Director – Resource and Energy Assessments
Department of Planning & Environment
GPO Box 39
SYDNEY NSW 2001

4 July 2018

Re: Submission – Application Number SSD 8882
Orange Grove Solar Farm – 1170 & 1354 Orange Grove Road, Gunnedah
(Lots 1 & 2 DP 945590, Lots 27 & 30 DP 754928, Lots 1 & 2 DP1068520, Lot 1 DP 1068518 and
Lots 1, 2 & 3 DP 126183)

Potential site access locations

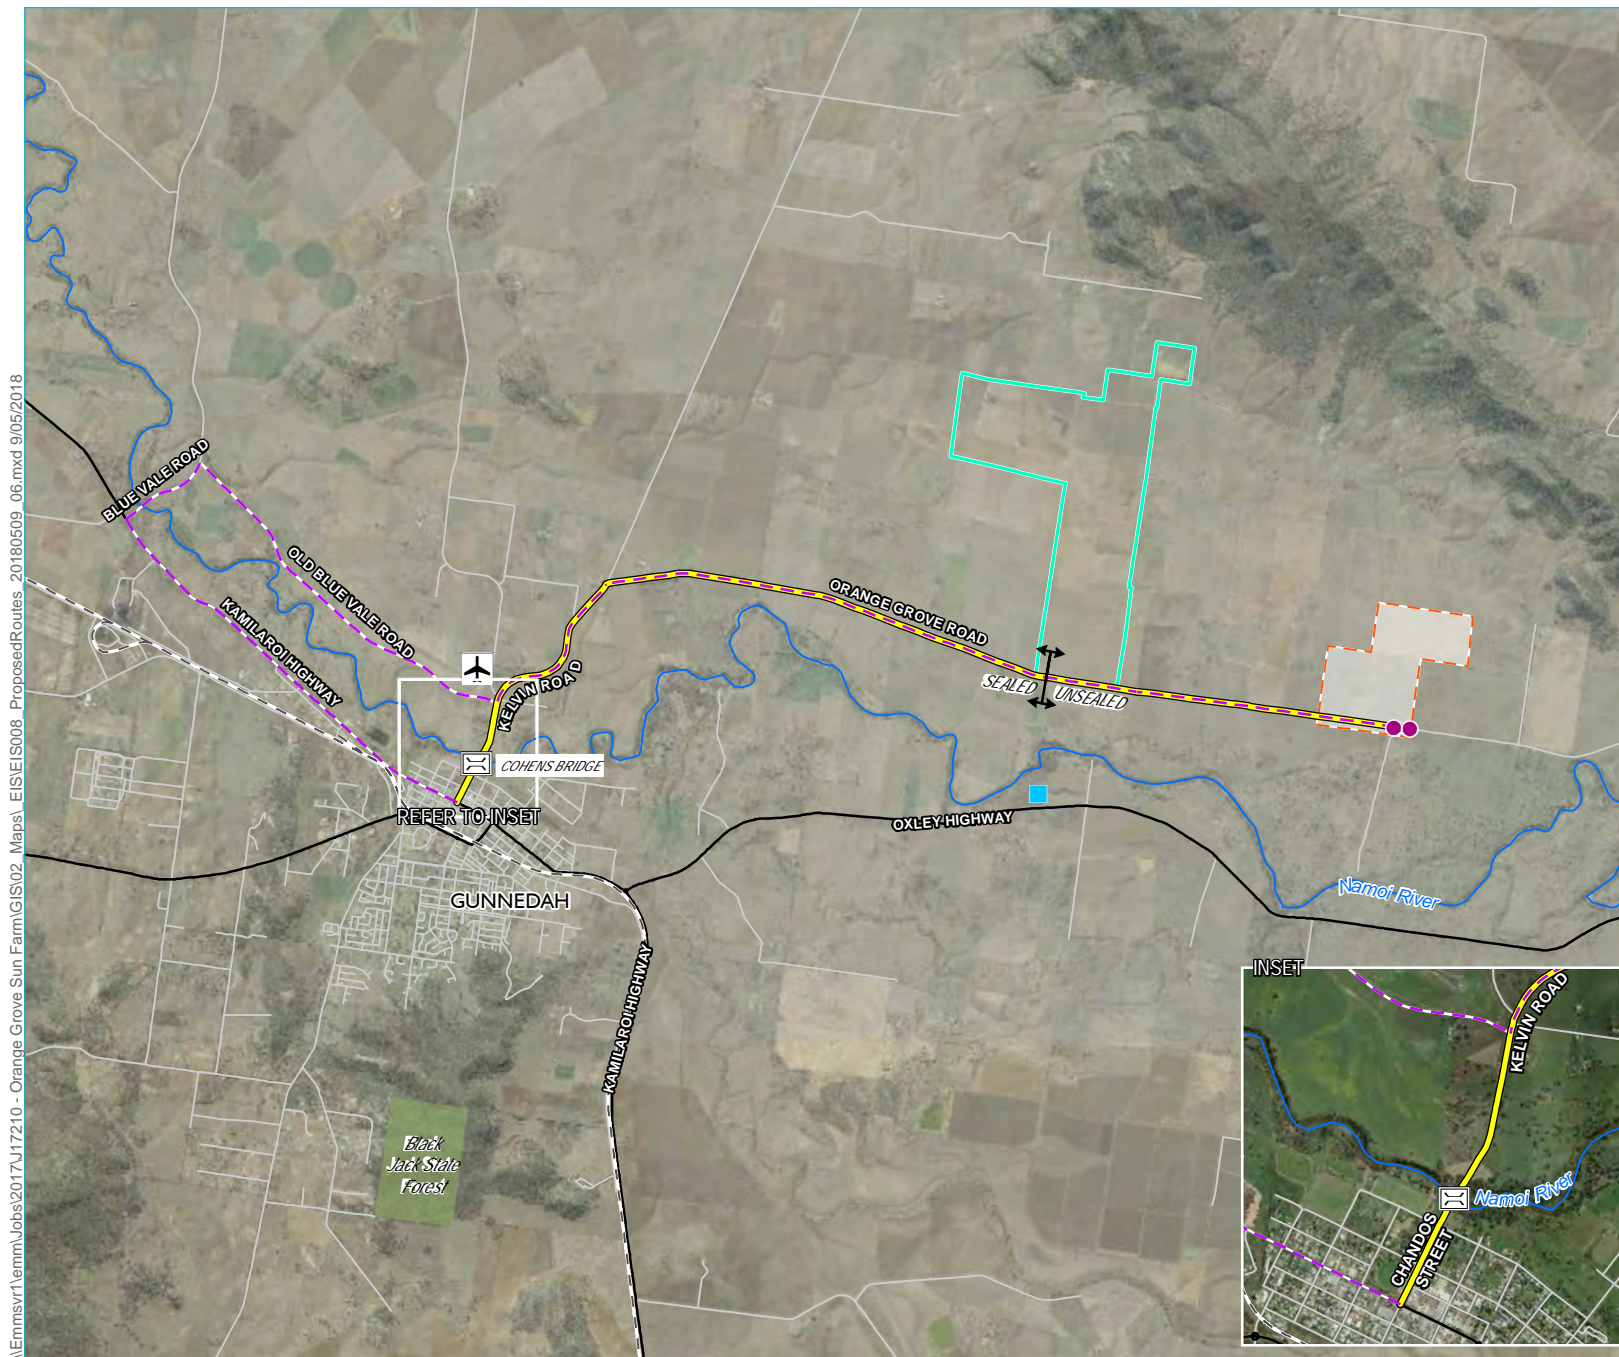
- A new access should be provided at the development site commensurate with the scale on the proposed development. As a minimum the RMS Typical Rural Property Access Standard for articulated vehicles should be provided.

- The access from Orange Grove Road to the proposed development should be sealed.
